WEST SUSSEX COUNTY COUNCIL CONSULTATION

TO:	Arun District Council FAO: Mrs A Gardner
FROM:	WSCC - Highways Authority
DATE:	17 June 2019
LOCATION:	Land adjacent to Scyld Horsemere Green Lane Littlehampton BN17 5QZ
SUBJECT:	CM/21/19/PL Construction of 9 no. dwellings, access, landscaping and associated works.
DATE OF SITE VISIT:	Monday 17th June 2019
RECOMMENDATION:	More Information
S106 CONTRIBUTION TOTAL:	£

FIGURE 1.3

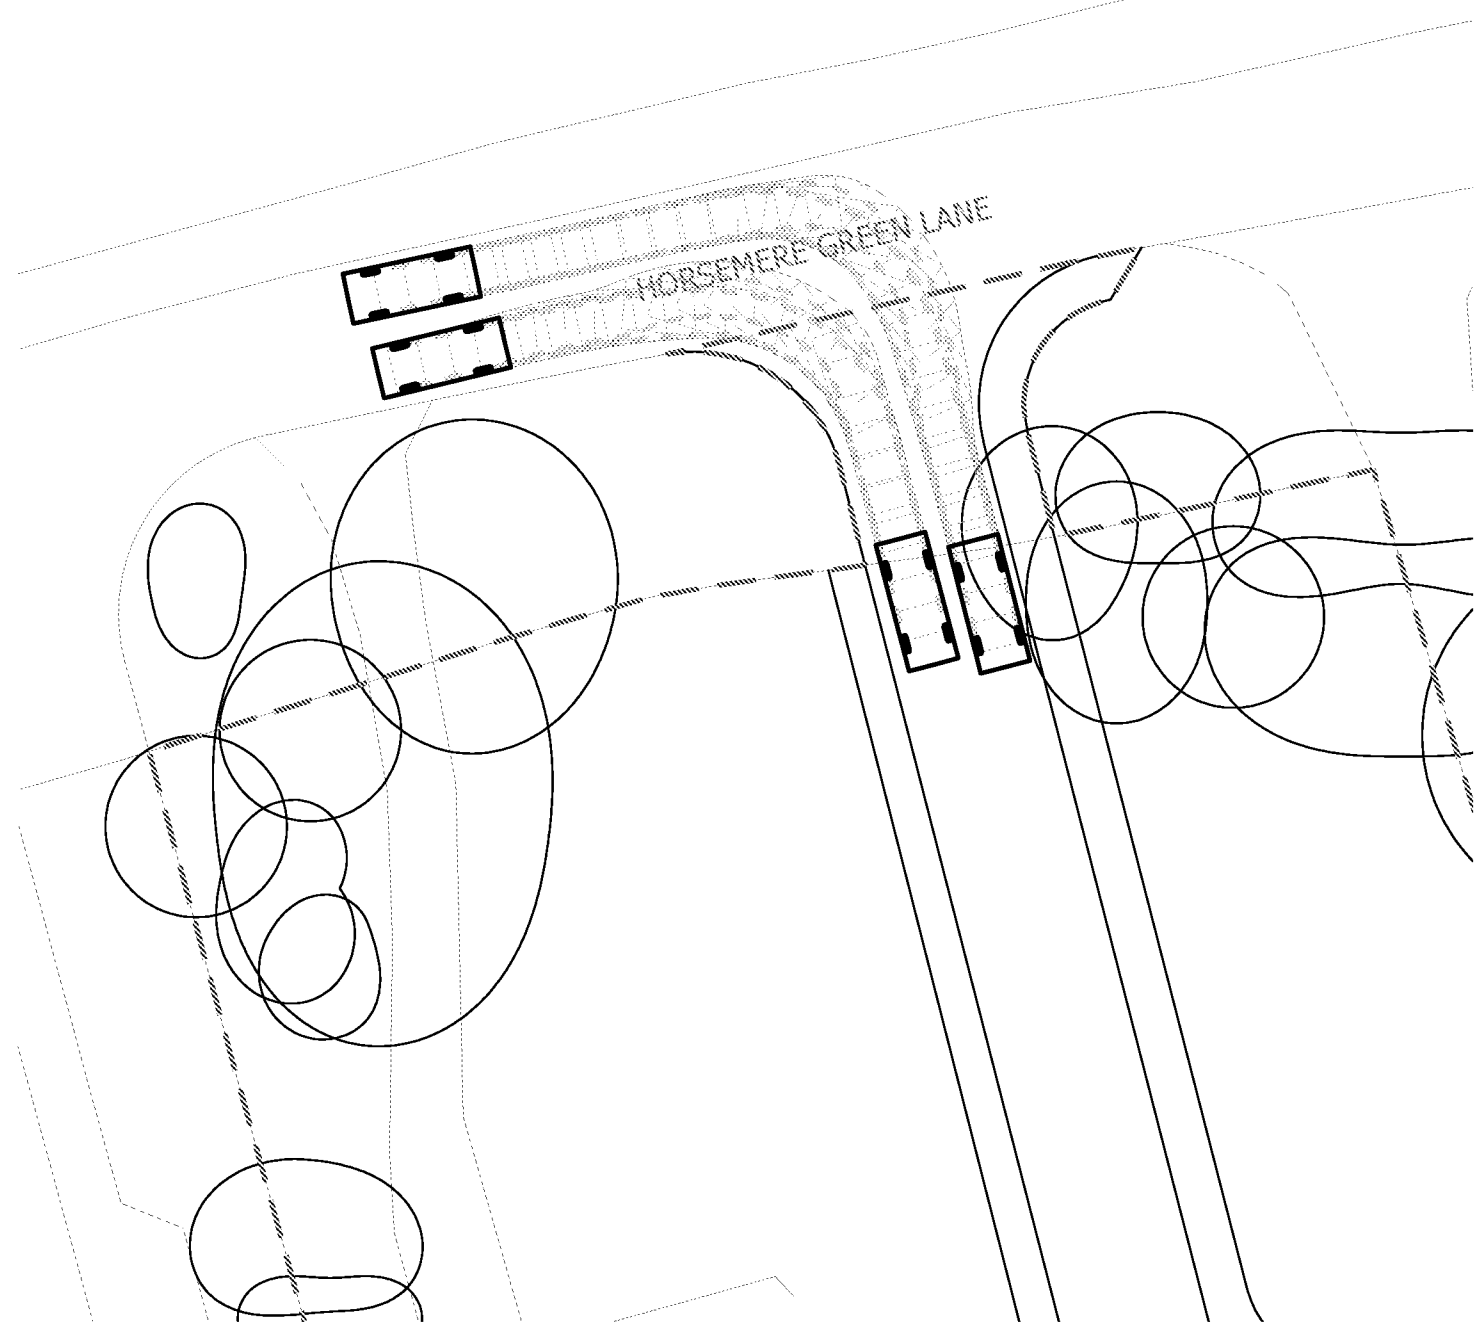
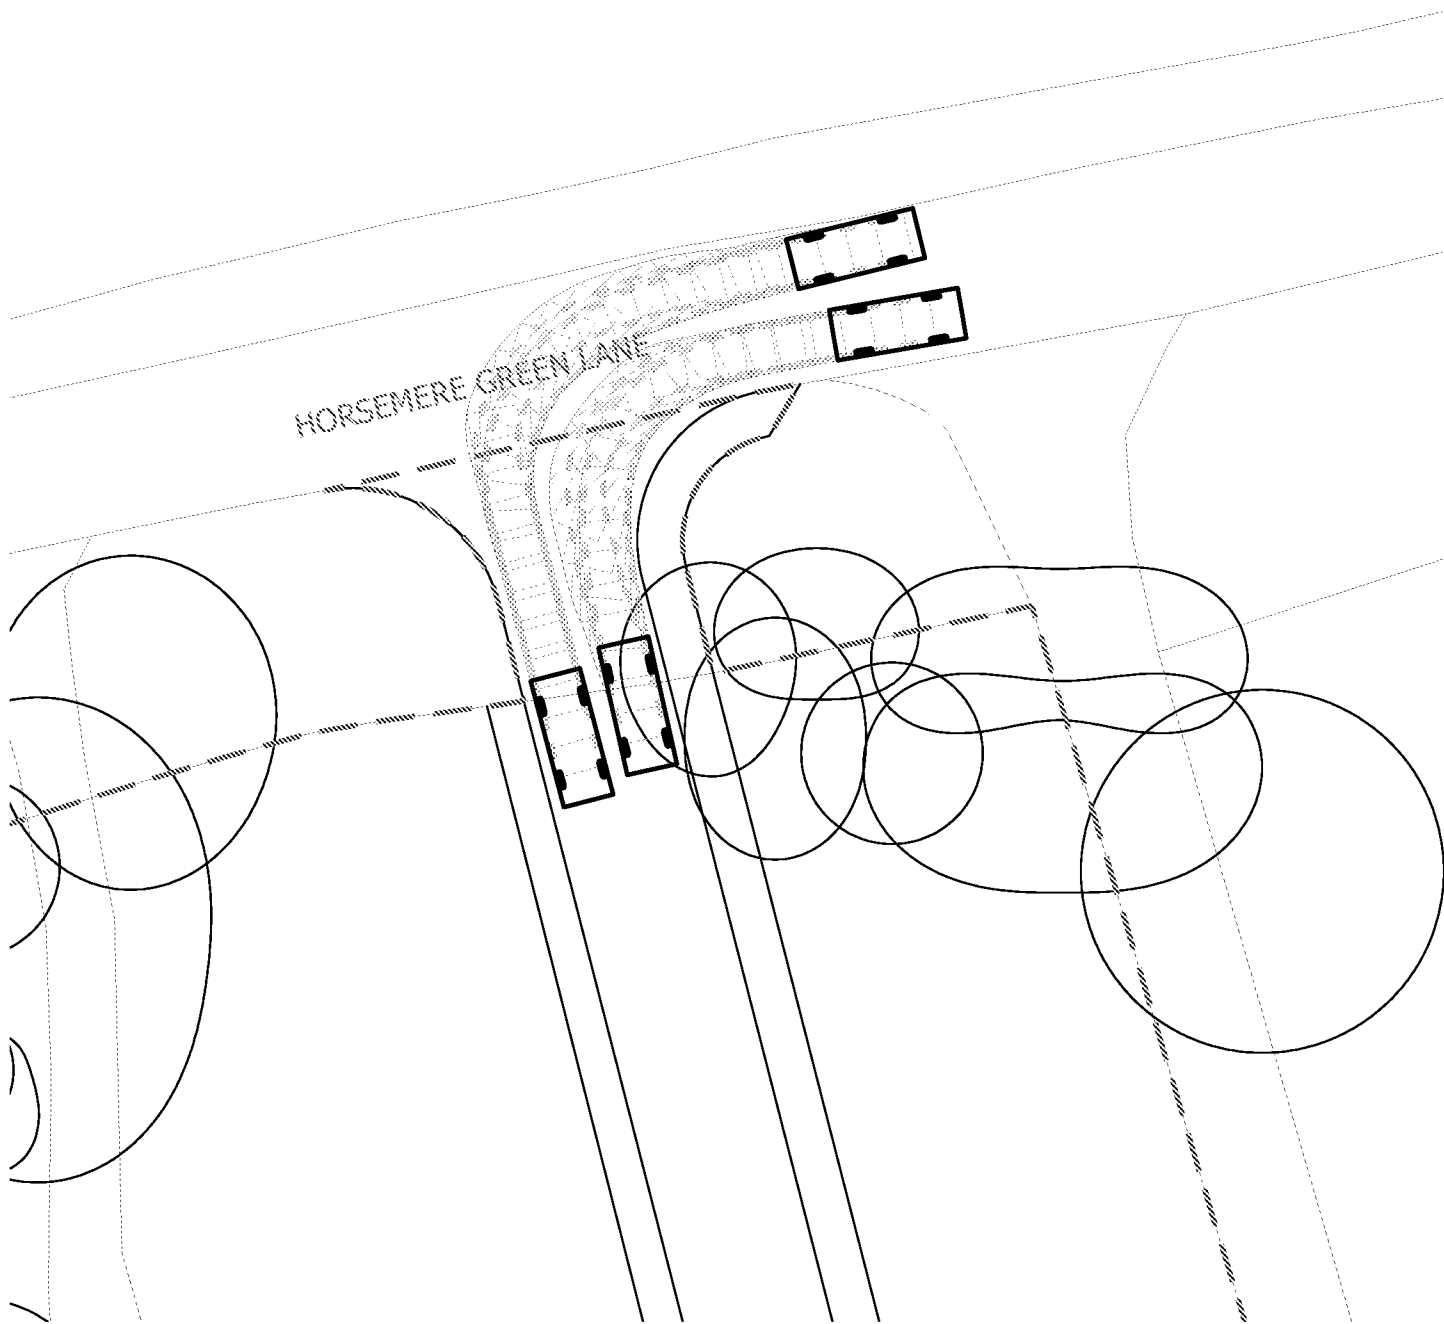
The new access will be a 4.8m access road with a bell mouth style access to accommodate two way passing traffic. Visibility splays in accordance with Manual for Streets (MfS) standards for a 30mph road have been demonstrated (43m). However when reviewing WSCC mapping and observations on site it is clear that visibility is greater in both directions, than that required for the speed limit. Maximum achievable visibility should be demonstrated on a new revised plan.

FIGURE 1.6

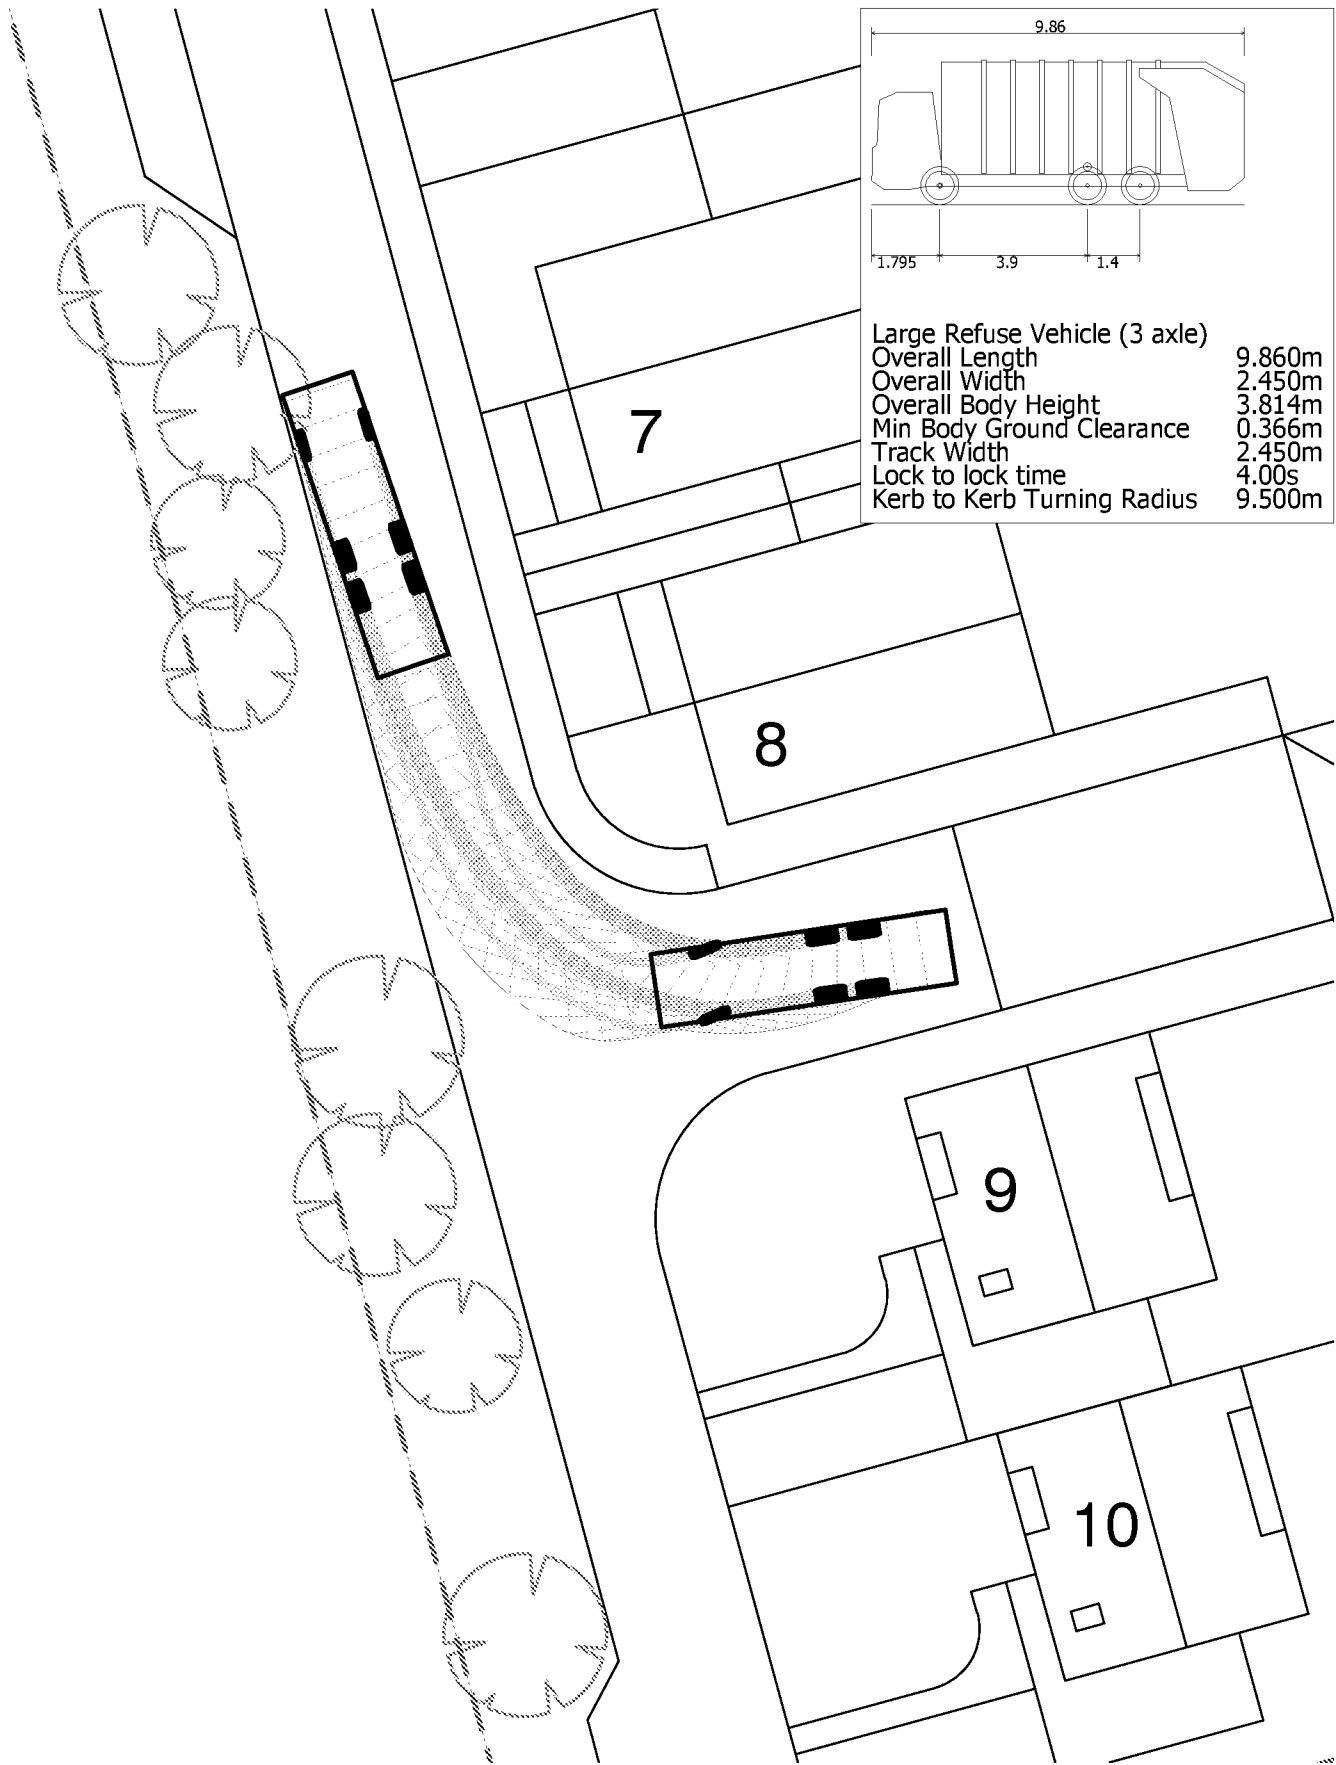
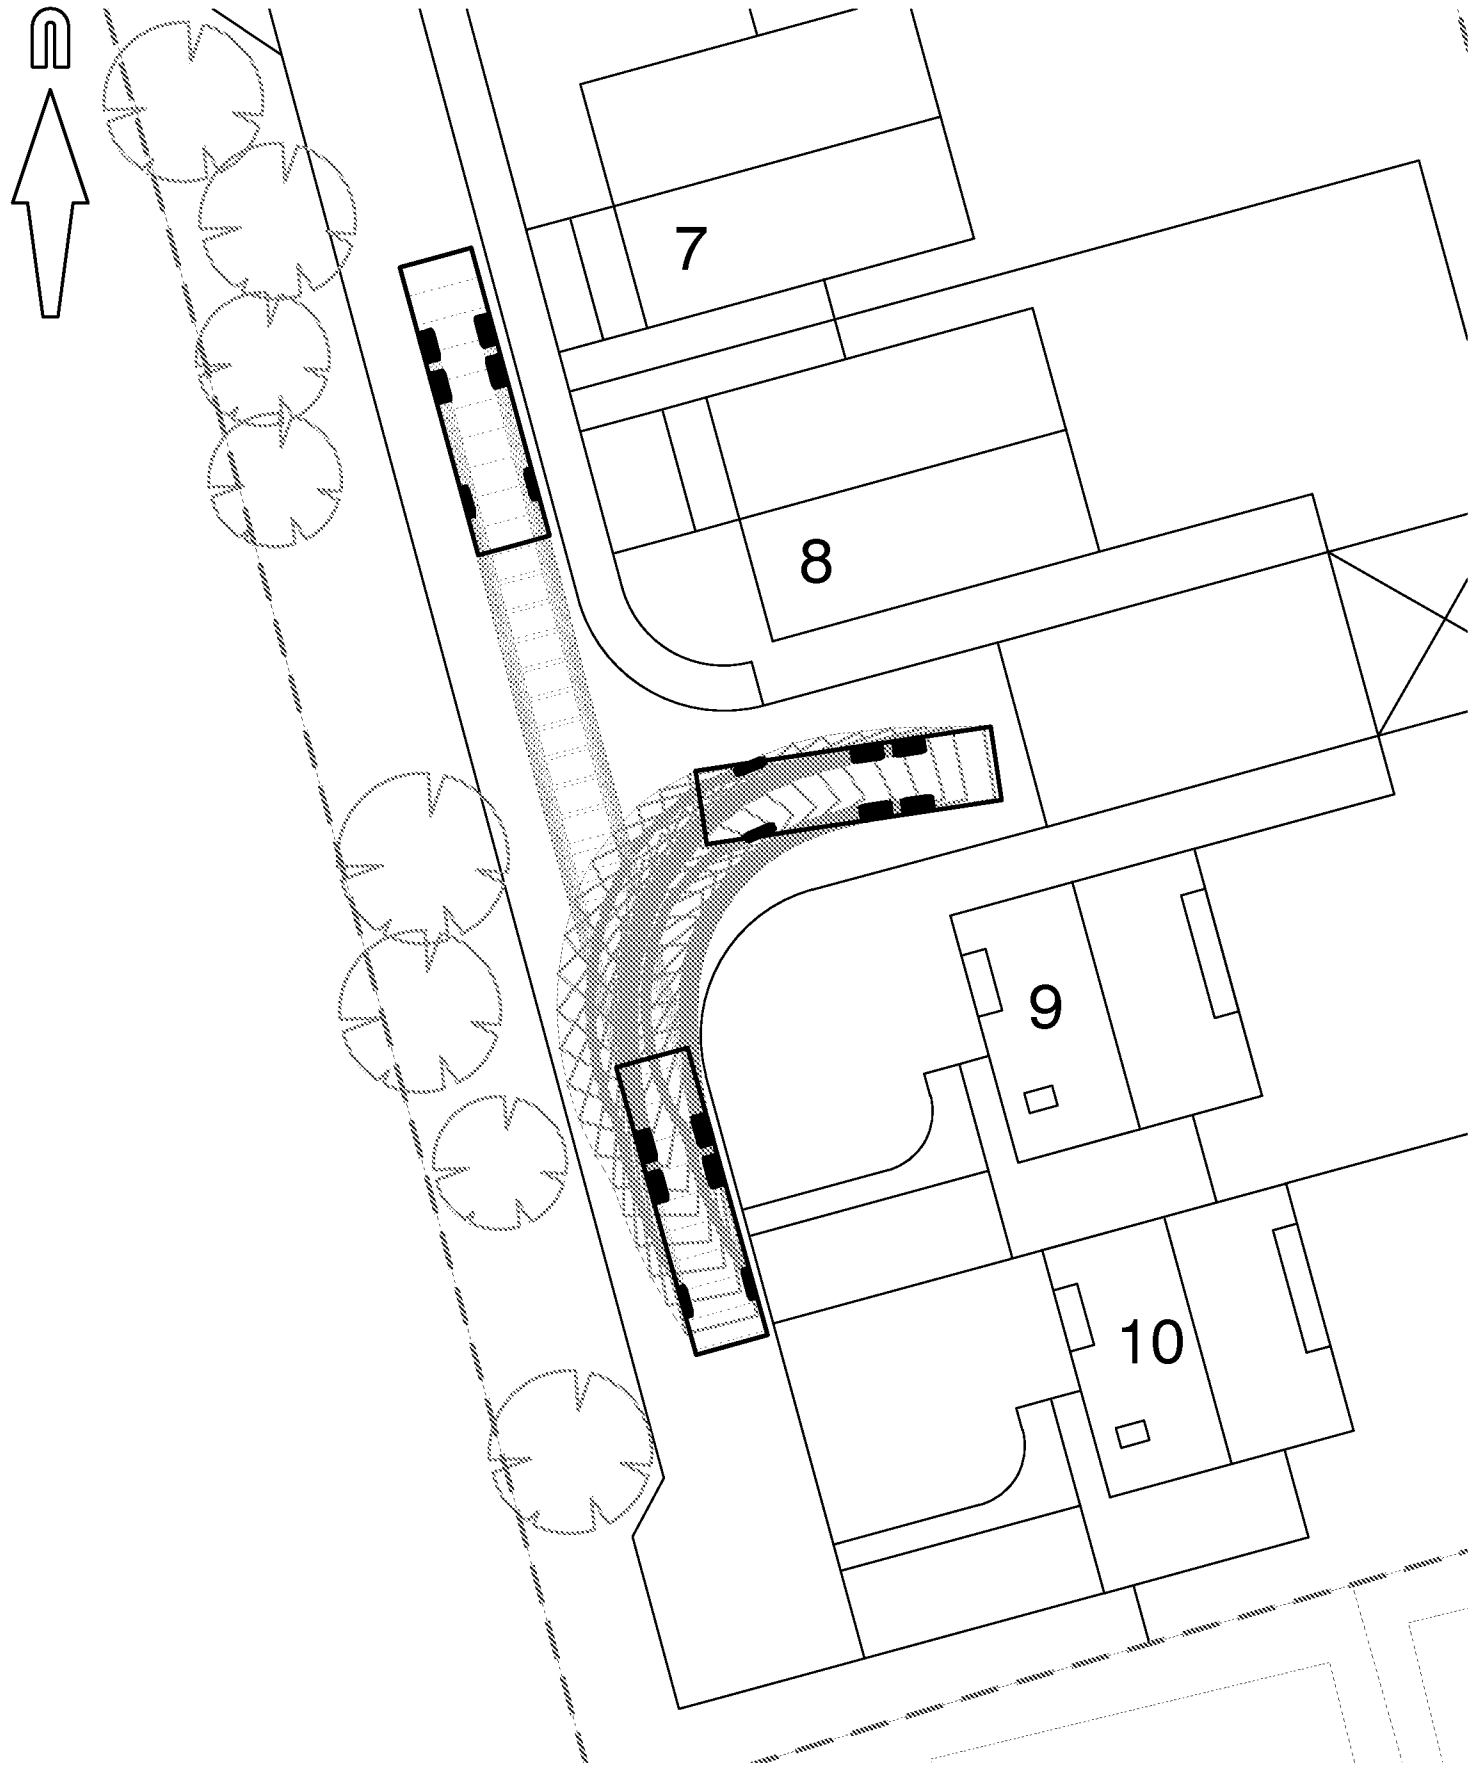
The proposal is to refurbish the existing dwelling on this site and build a further 9 dwellings. The existing dwelling would be served by its existing access. The new dwellings would be served by a new access. The planning documents are unclear, clarification needs to be provided on the access arrangements. The site plan doesn't show the existing dwelling access and its proximity to the proposed new access. It was clear from the site visit that there is a build out in close proximity to these access points, this needs to be taken account of on the planning drawings and tracking diagrams.
